Arun District Council
Arun Civic Centre
Maltravers Road
Littlehampton
West Sussex BN17 5LF
Planning & Building Control General Enquiries
Tel: (01903) 737756 Fax: (01903) 730442
Dx: 57406 Littlehampton
Minicom: 01903 732765
e-mail: planning@arun.gov.uk
website: www.arun.gov.uk/planning

Application No: BN/18/20/PL
Site Address: Former Brooks Nursery Eastergate
Description of works: Variation of condition 15 imposed under EG/29/13/ relating to condition 15 - to change the foul drainage scheme from Sewage Treatment Plant to Pumping Station with associated drainage works.

Thank you for your internet representation made on 19th June 2020 which has been recorded as an objection with the comments as follows:

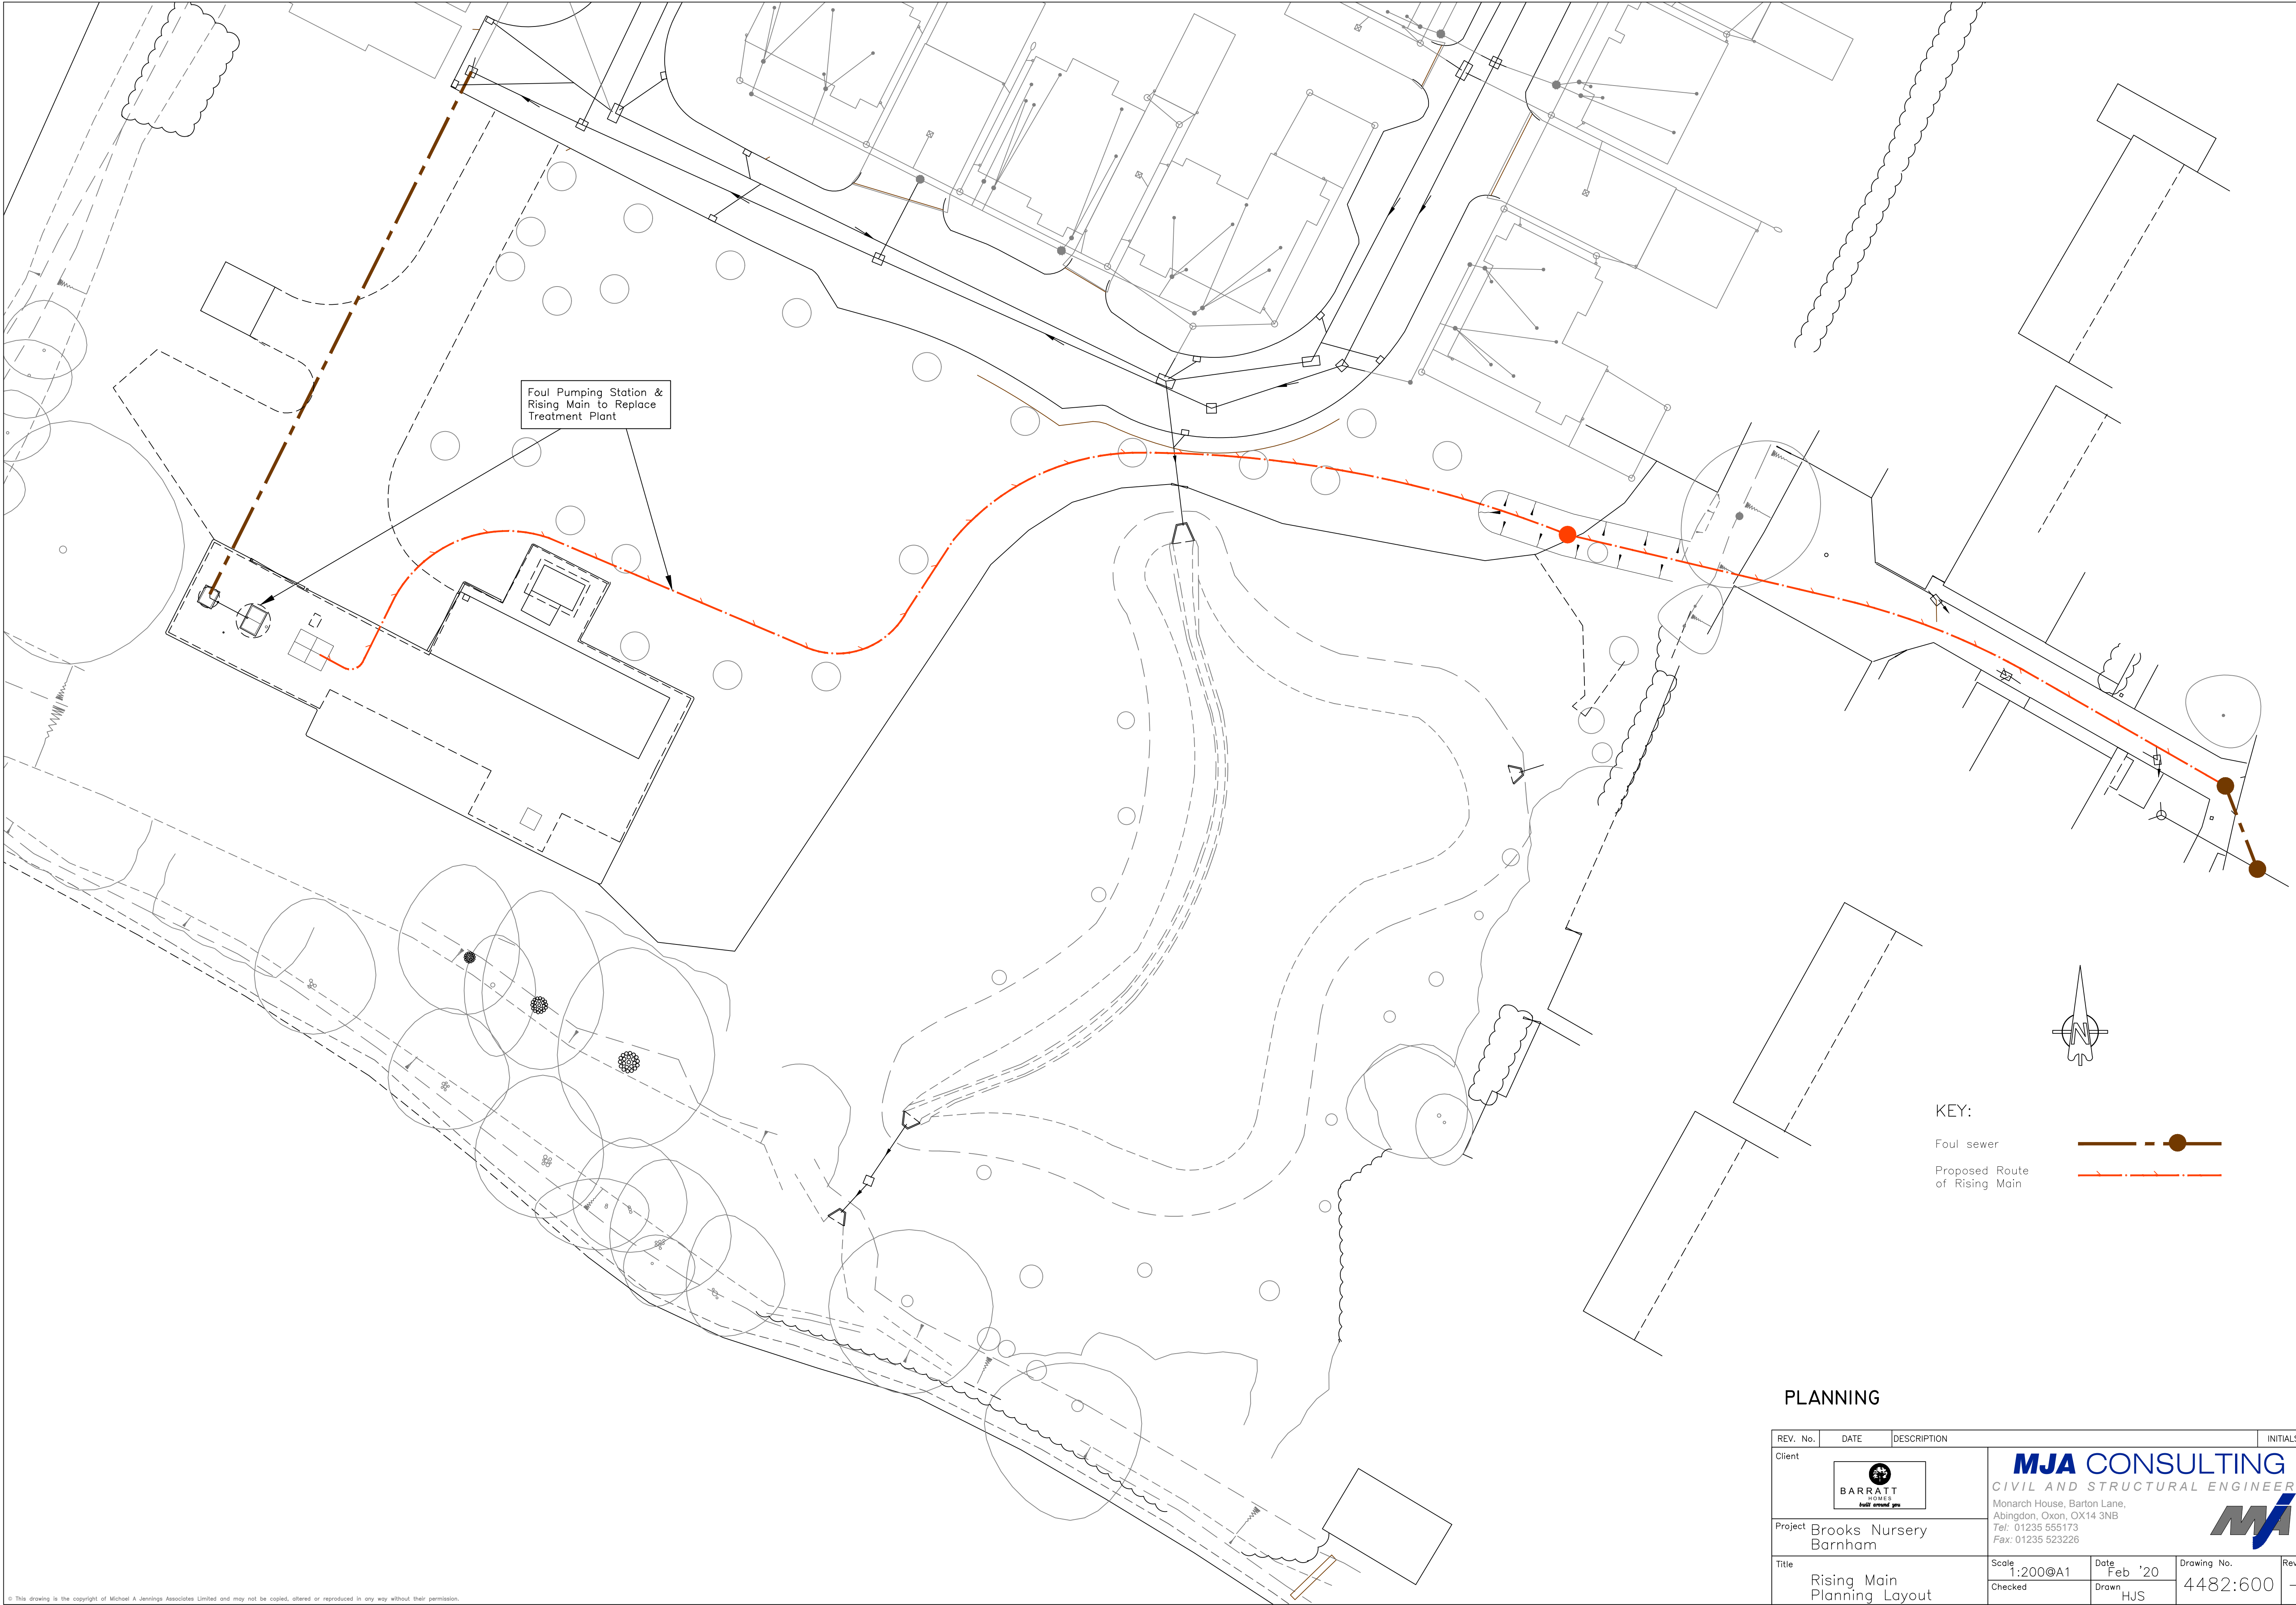
The connection of a 8 inch pressurised sewerage pipe (with non-return valves) to an antiquated (and already overloaded) 6 inch gravity sewage pipe, is clearly not a sensible thing to do in any shape or form; particularly given the increasing strain of housing and increase in pupil numbers at St Philip Howard School. As the headteacher of the school and in consultation with governors, we strongly object to these plans and urge decision-makers to reject these proposals. As the school lies one meter below the surrounding roads, surface water already runs off from these roads (where there are very few drains) into the school site (an ex-brick yard with clay composite soil). We experience considerable flooding with minimal amounts of rain, regularly cutting off the school car park and swamping the playground and field. With wider housing schemes and developments being planned for we are fearful that local drainage and sewage is simply not coping adequately and places the children entrusted to our care at considerable risk - both in terms of their health and in terms of further disruption to their learning (following recent school closures) should we not be able to open the school site. We have not been consulted on this scheme at any stage and believe that as a provider of local services should have been.
